200 Aldington Road Industrial Estate (SSD-10479)
Request for additional information

I refer to the Response to Submissions (RtS) report submitted for the 200 Aldington Road Industrial Estate (SSD-10479). The Department is requesting that you provide additional information.

Attachment 1

Attachment 2 – Noise and Vibration Impact Assessment (NVIA)

**Figure 9 – Plan of Defendable Spaces.**

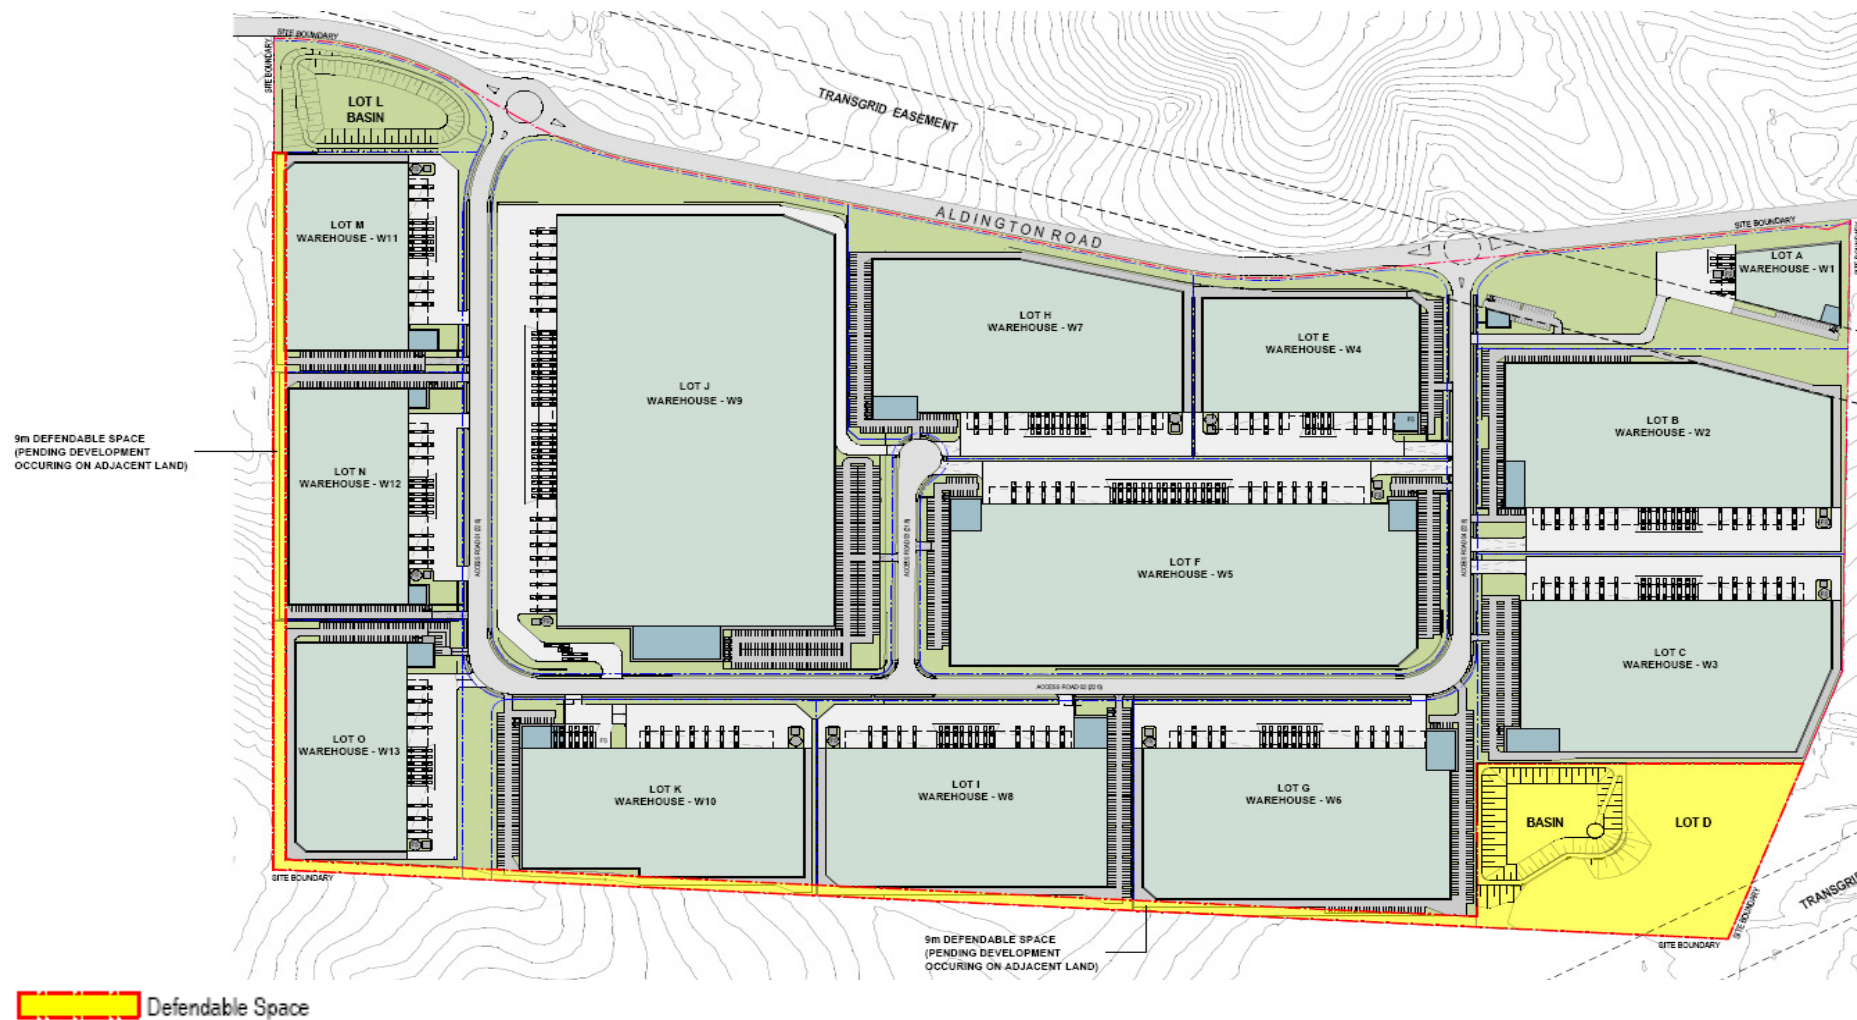
13. The location of defendable space within the RE2 and E2 zones on the site conflicts with Section 2.2.3 of the MRP DCP, which requires Asset Protection Zones to be located wholly within the IN1 zone.
